14/12/2020

**Waterloo Metro Quarter State Significant Developments
(SSD-10437, SSD-10438, SSD-10439, SSD-10440 and SSD-10441)
Response to Submissions**

Attachment A

DRAWING
LANDSCAPE PLAN
GROUND FLOOR

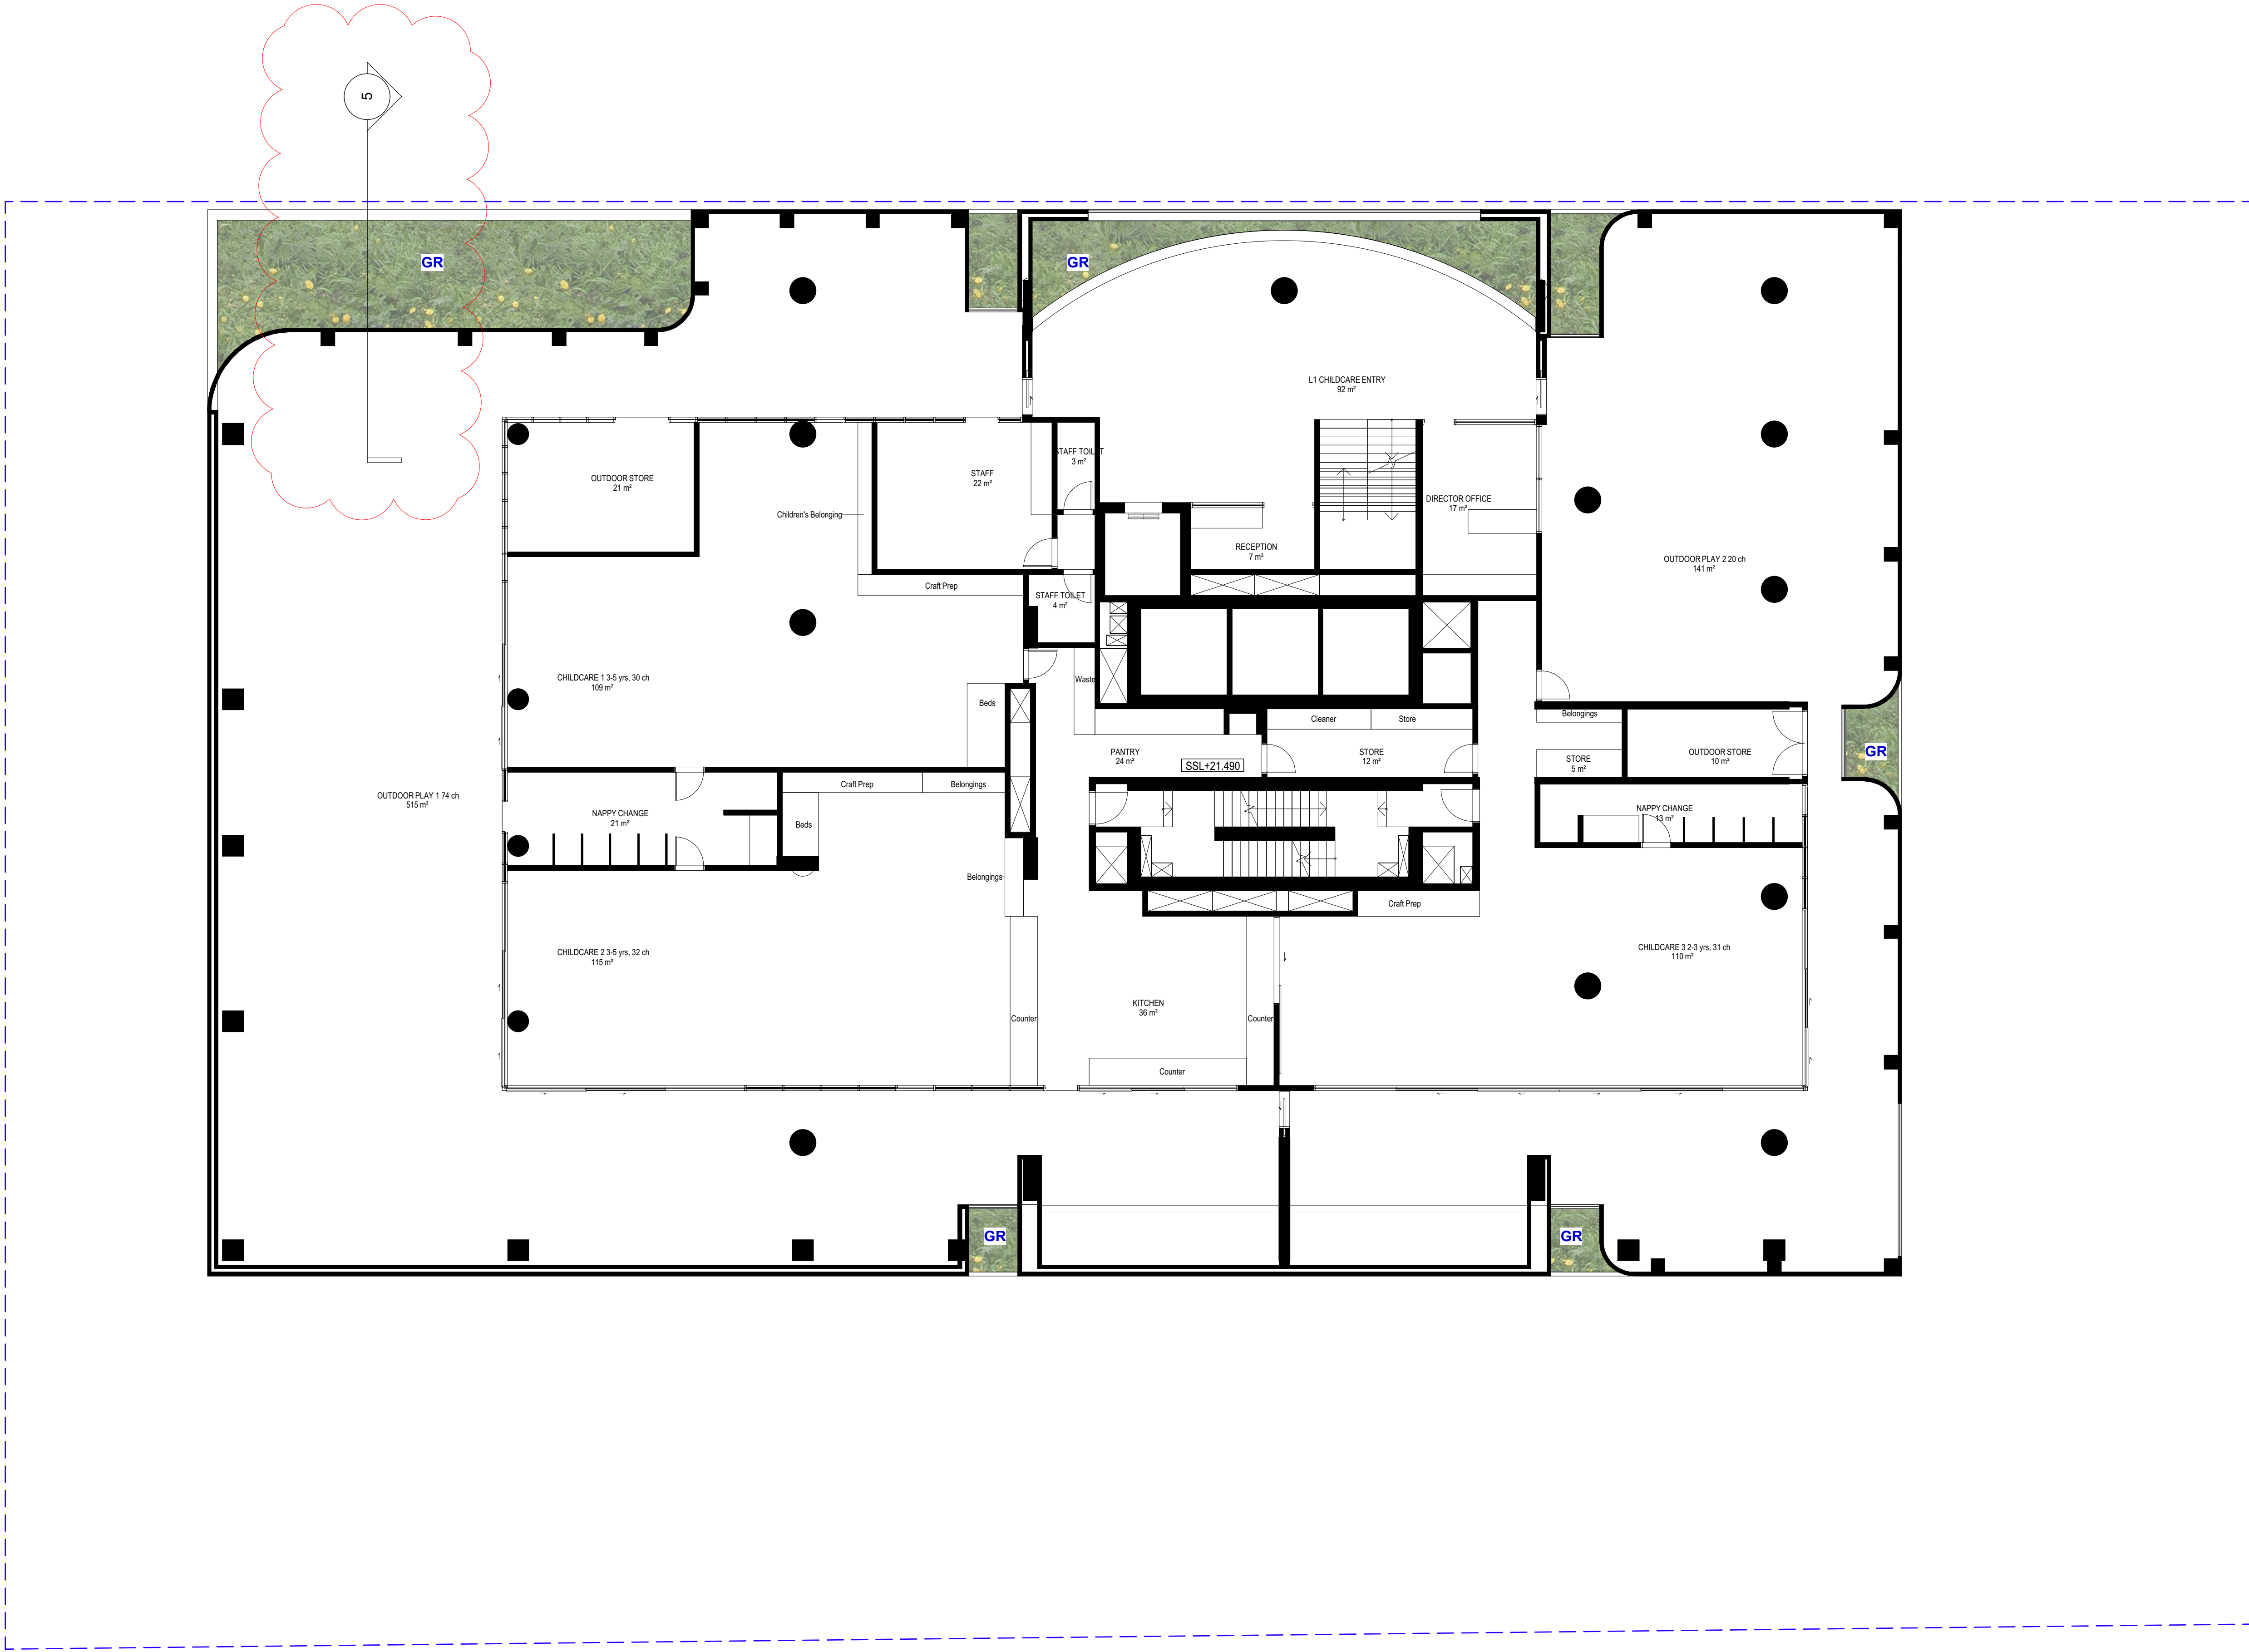
- e. Provide further information on how the proposed retail premises can be serviced from basement loading docks.

SECTION 5 1:25
LEVEL 1 - CHILD CARE CENTRE PLANTER

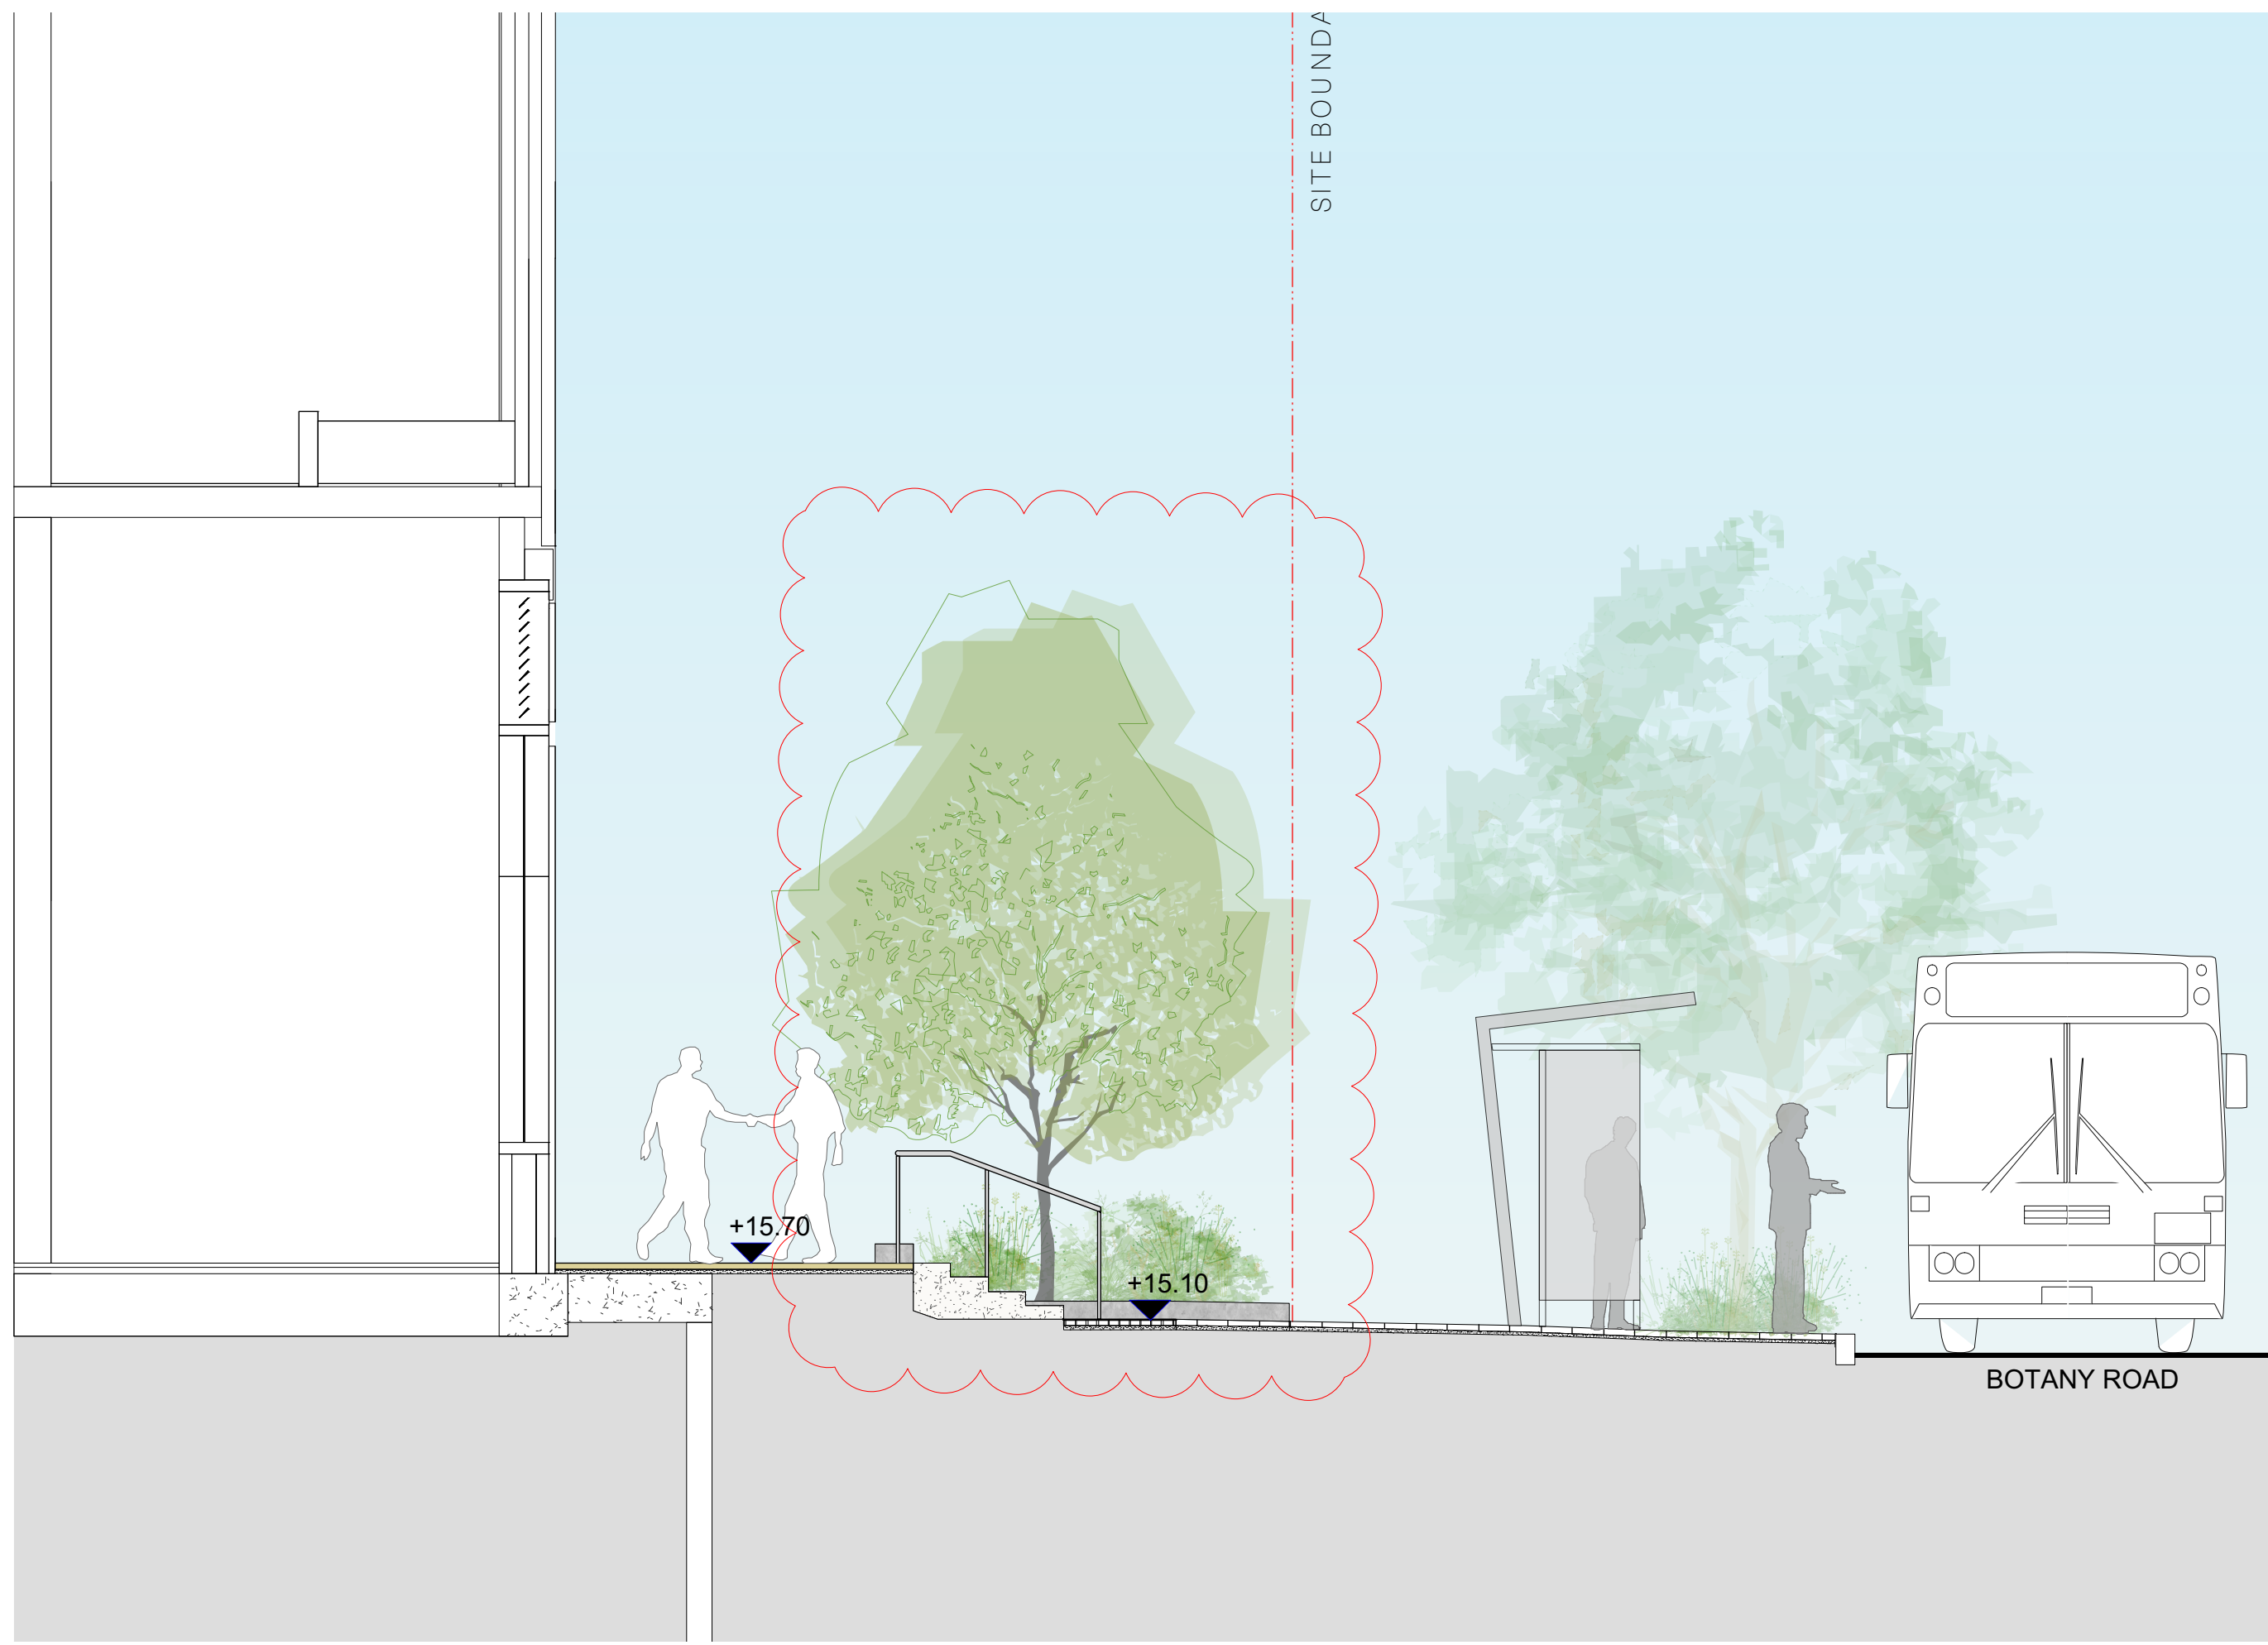
- the size of the floorplate dimensions and building services that would allow grouping of children into separate play spaces, with the required amenity and supervision
